DECISION DELEGATED TO HEAD OF PLANNING

Application No: H16-0803-21 **Applicant:** Mr I Buckley

Proposal: Extensions and alterations and replacement septic tank

Location: 145 Bourne Road Spalding

Proposed Front Elevation

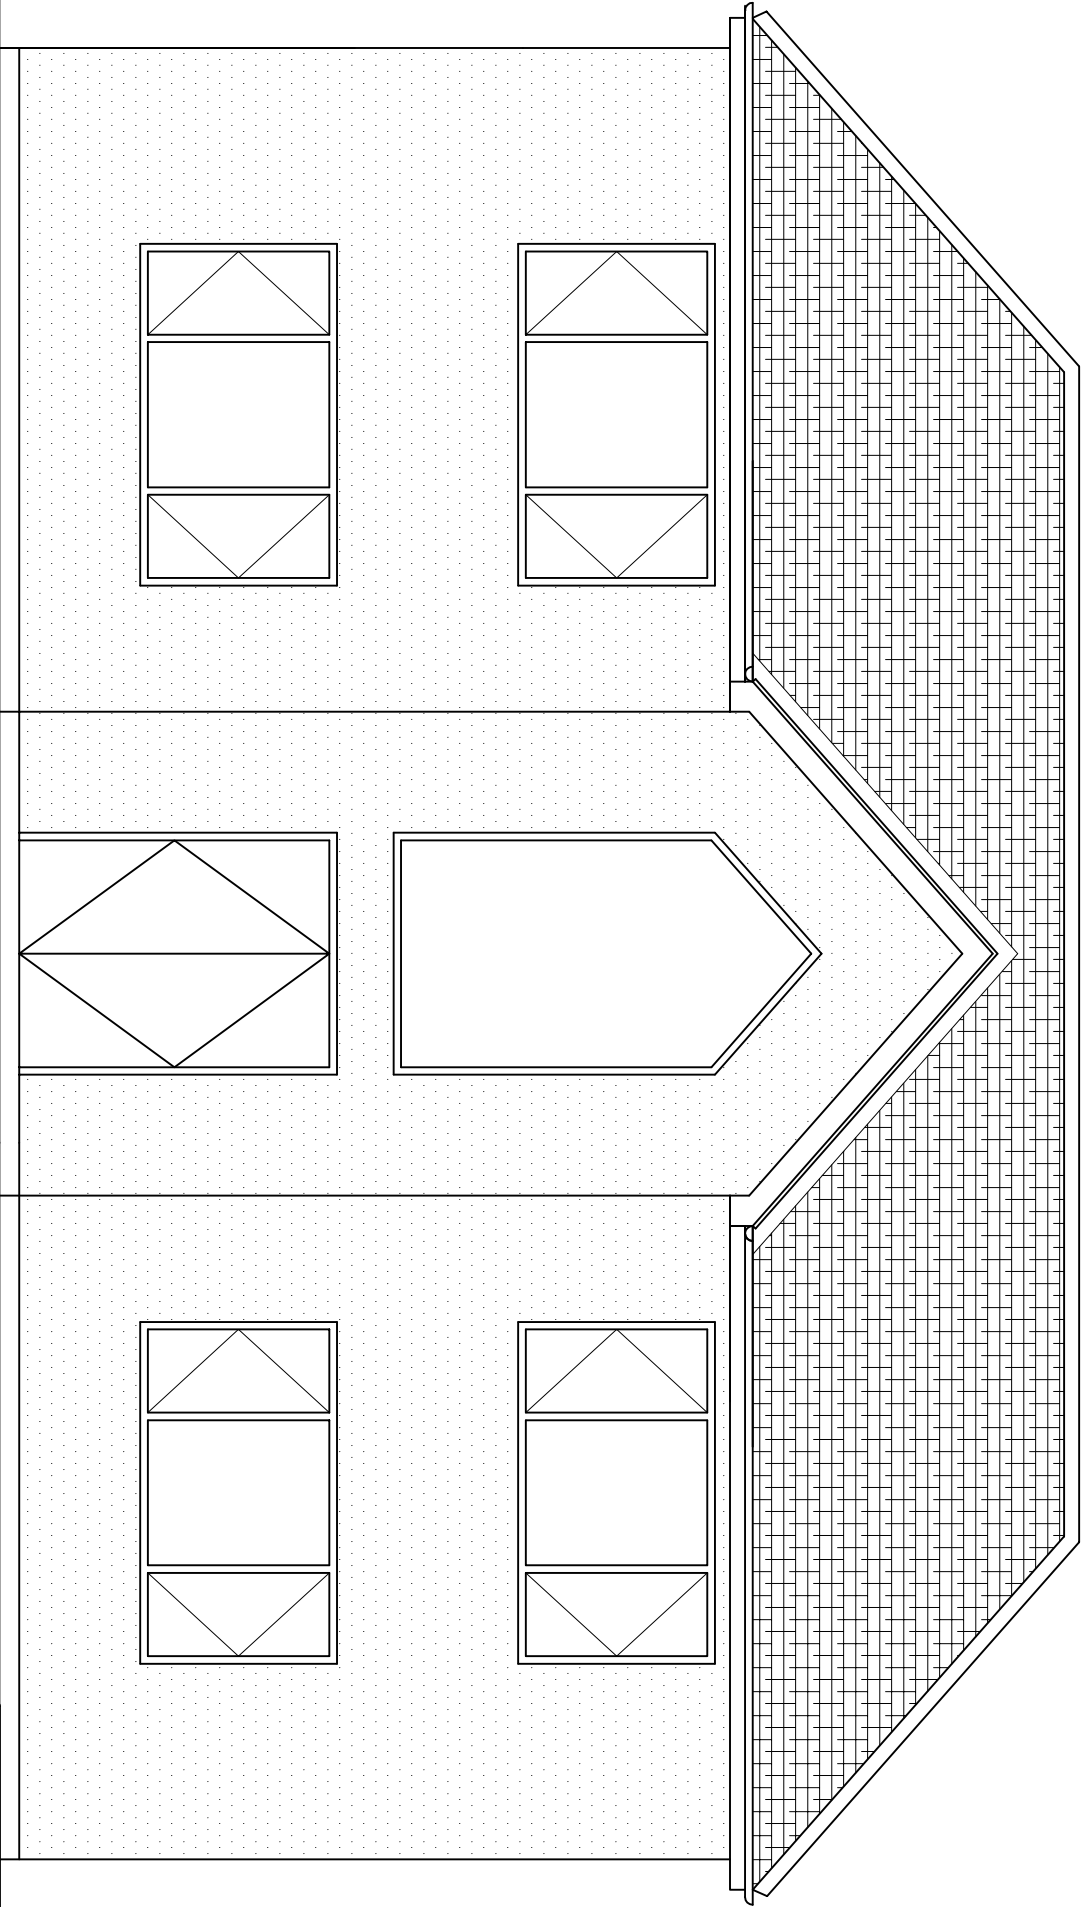
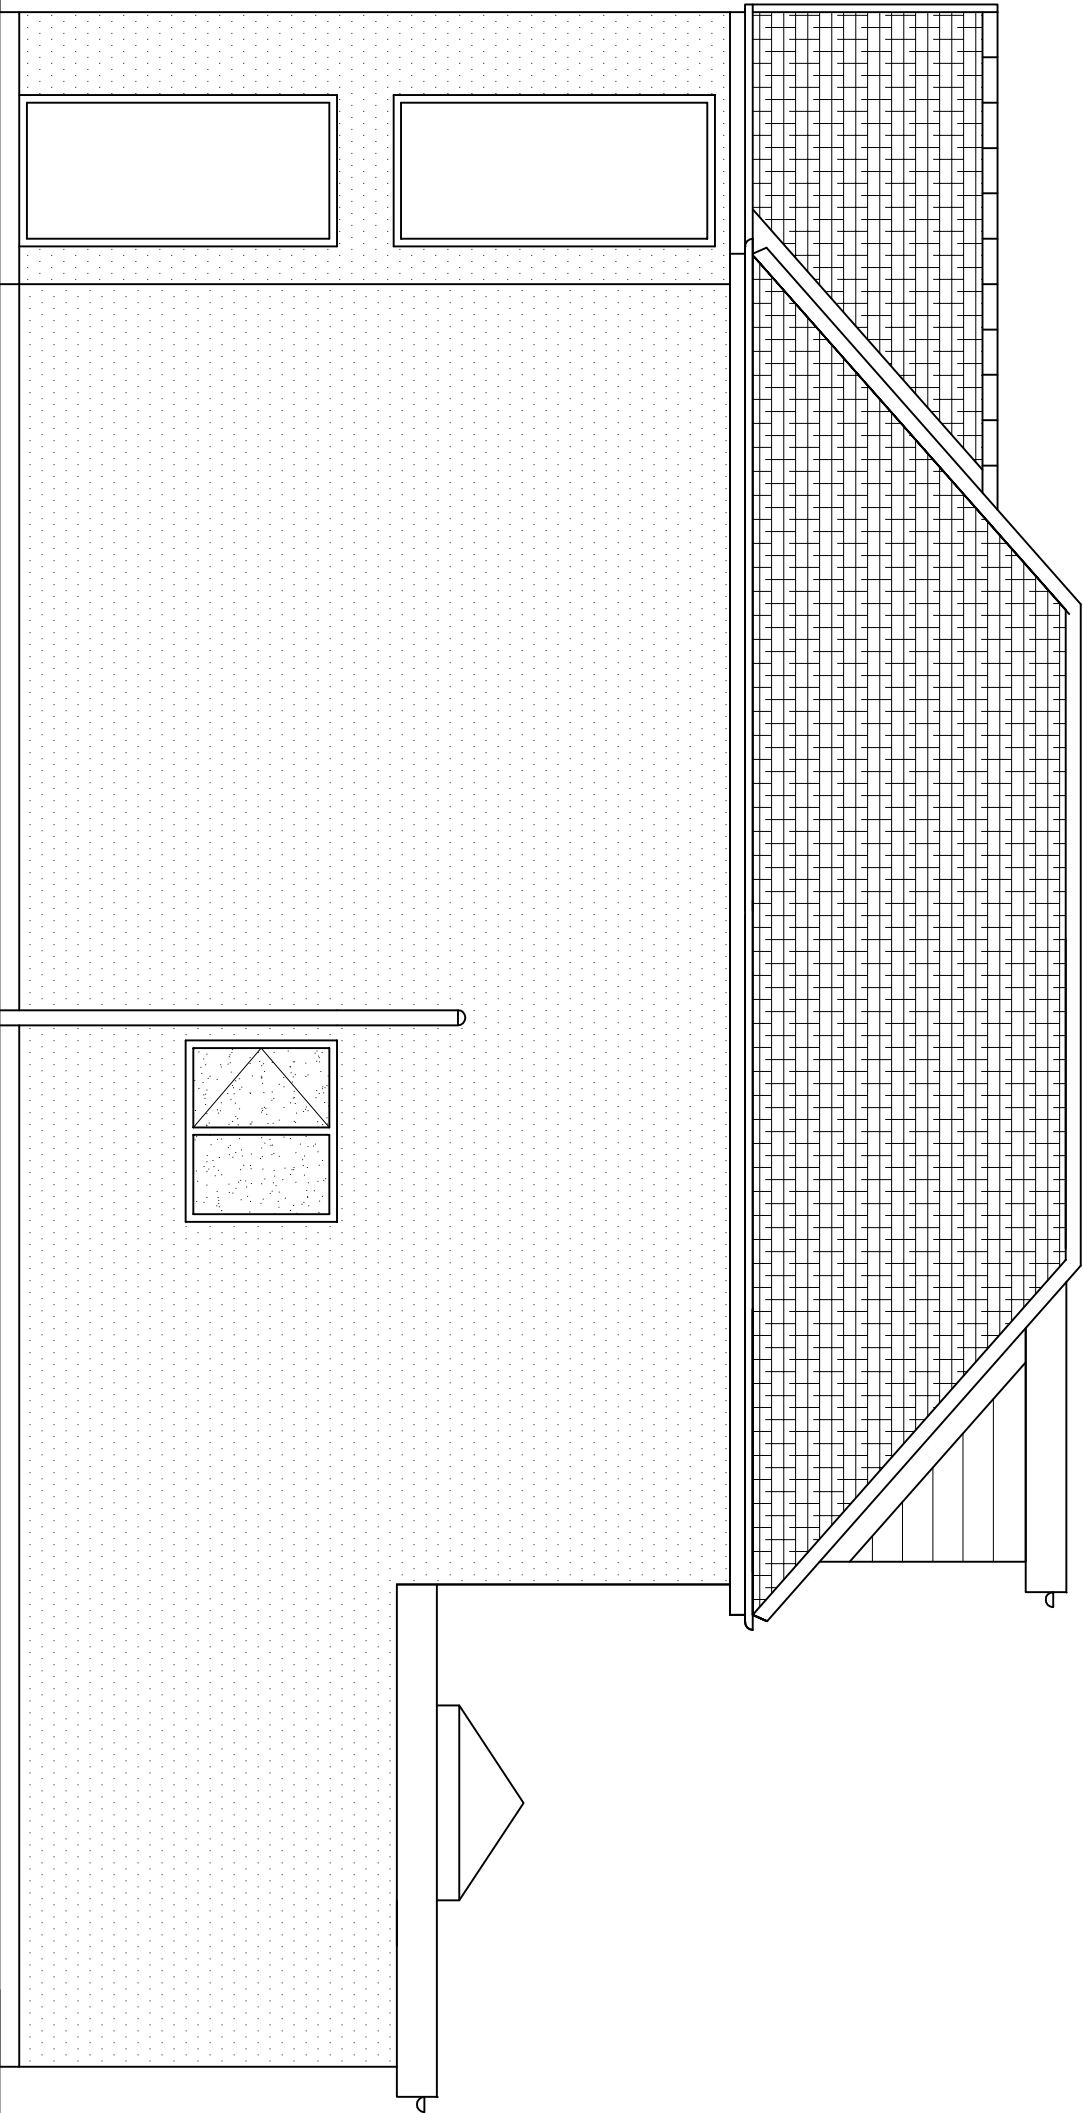
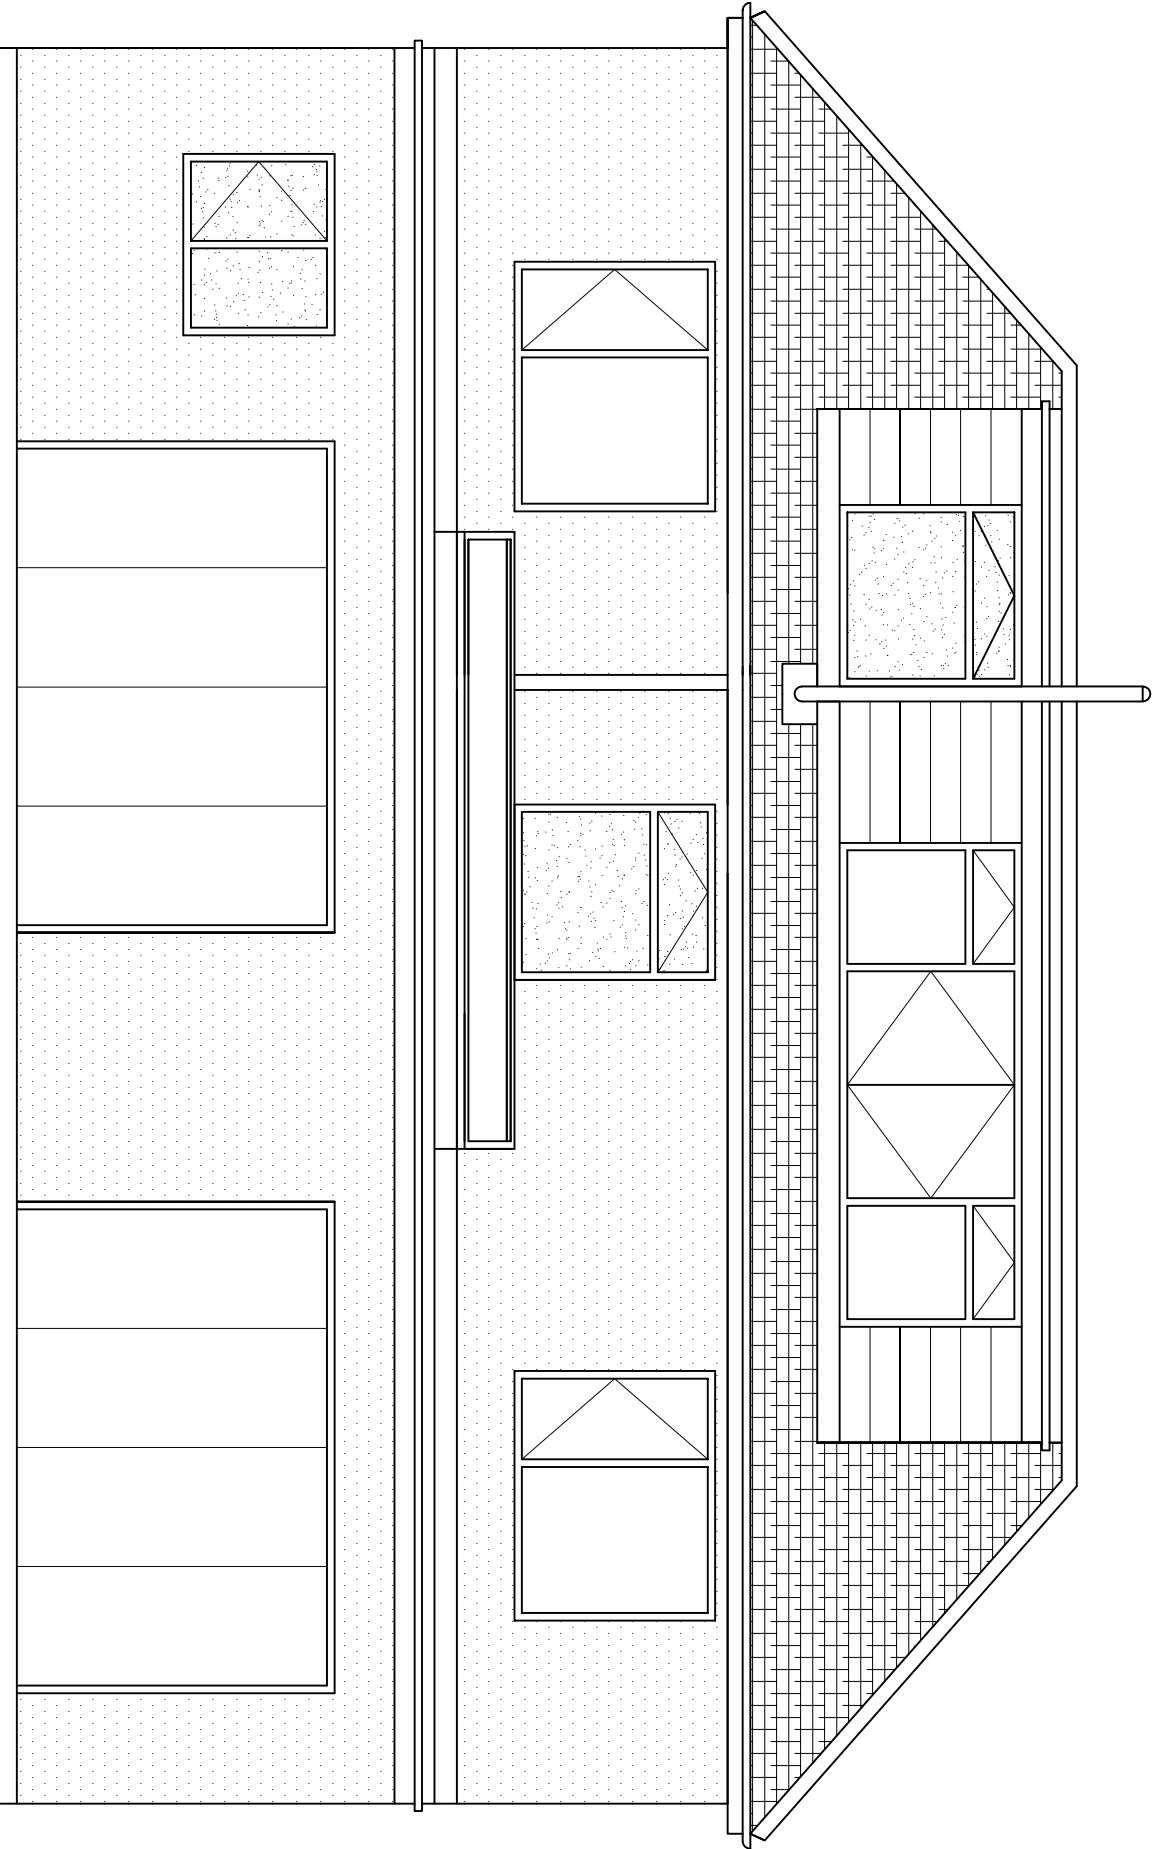
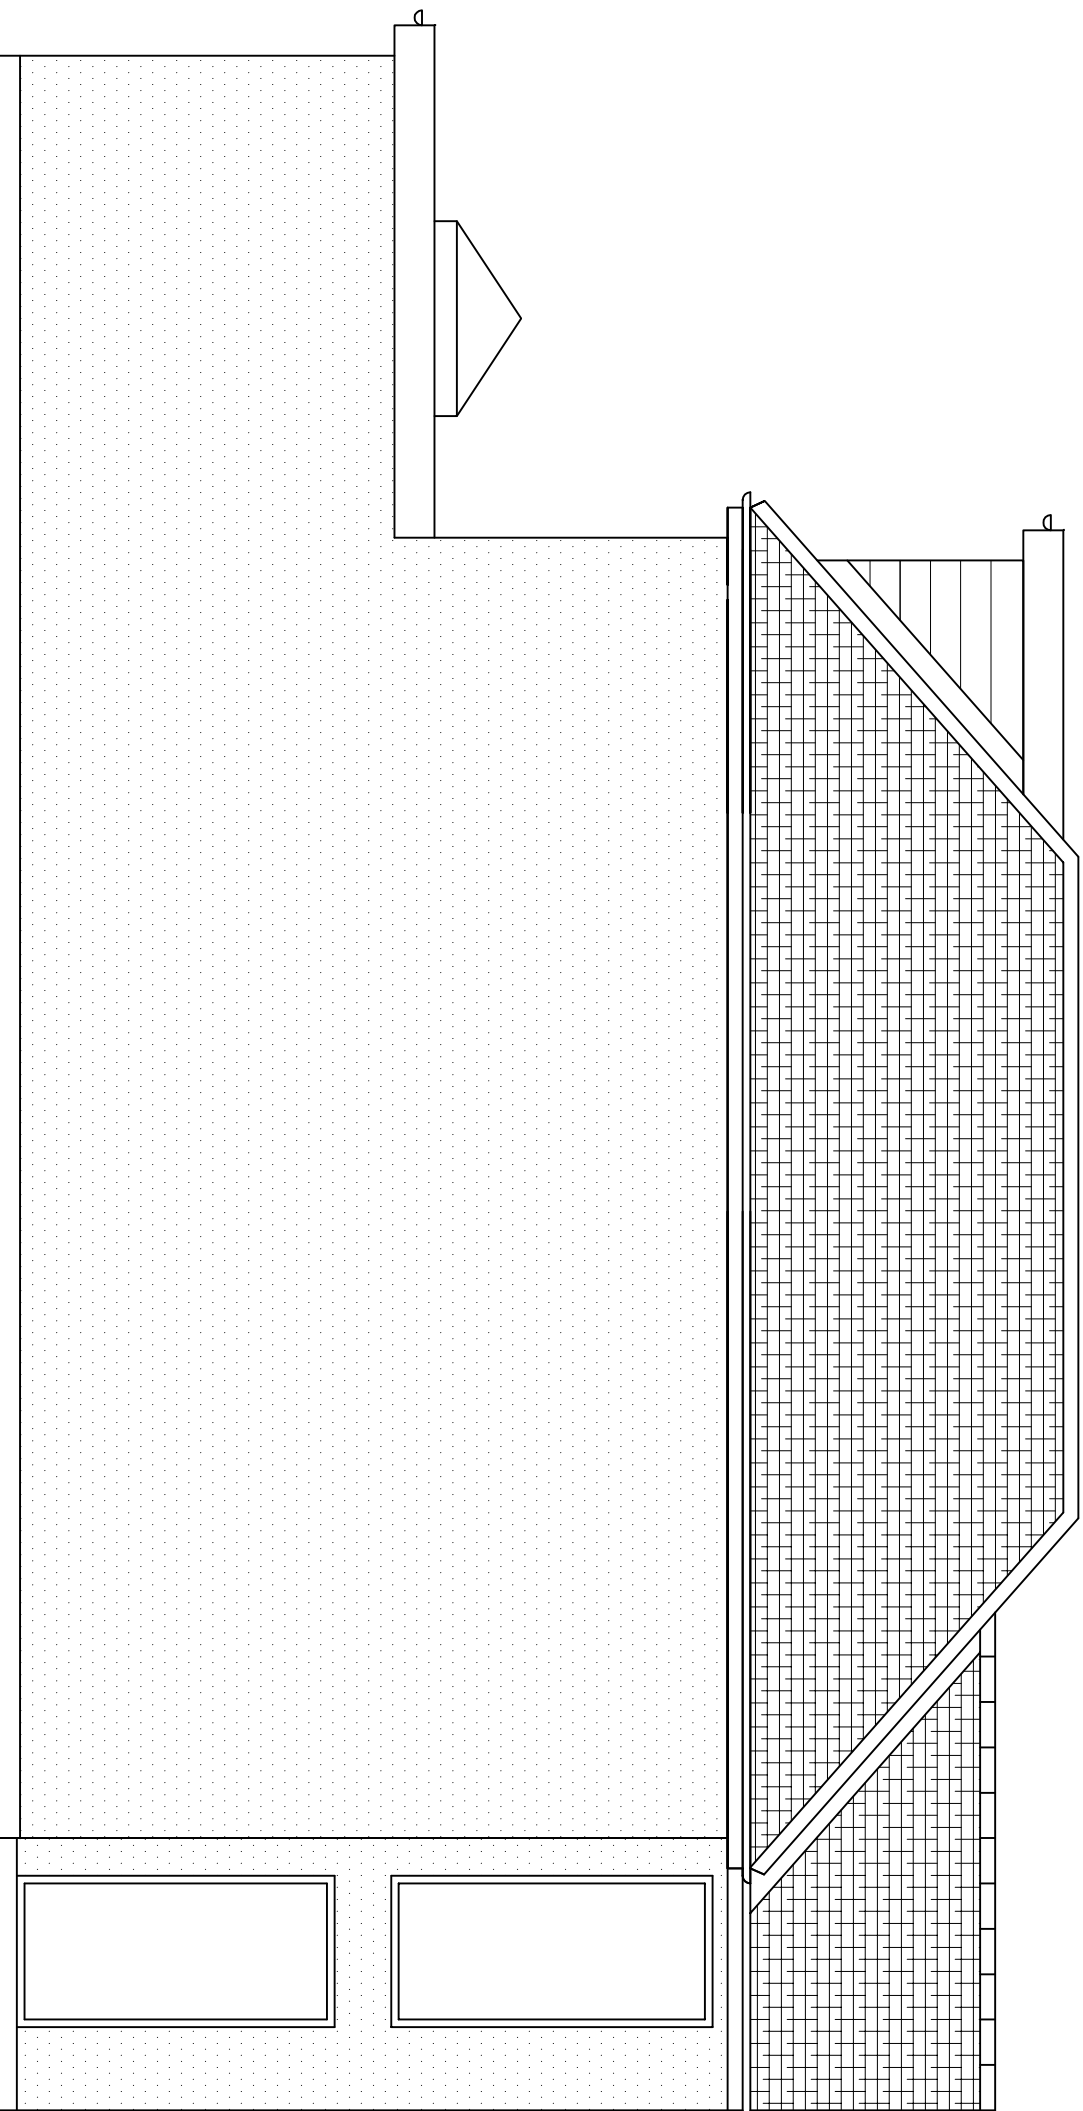
First and second floor make the property considerably larger and no.143 Bourne Road is more likely to get overshadowing and loss of light and sun. In fact, as it being proposed to build higher and nearer on the West to no.143 and likely to suffer loss of light, overshadowing and having an overbearing property affecting the quality of life.

The proposal does not include any windows to the side elevations on the first and second floors to the main part of the dwelling. The side facing ground floor window would be to a W/C and therefore obscure glazed. To the front of the dwelling is a two storey project to accommodate an entrance hall at ground floor and a seating area at first floor. The windows to the seating area would not create a material overlooking aspect due to the angles to windows of neighbouring properties. The windows to the front and rear will just have a typical relationship with neighbouring dwellings for a frontage property.

It is not considered that the proposed extensions would be overbearing in nature. The extension to round off the property at the front would be approx. 6m from the neighbouring dwelling and would appear to face a non-habitable room. The dwelling to the east has no side facing windows and the rear extension would extend no further south than either of the neighbouring dwellings.
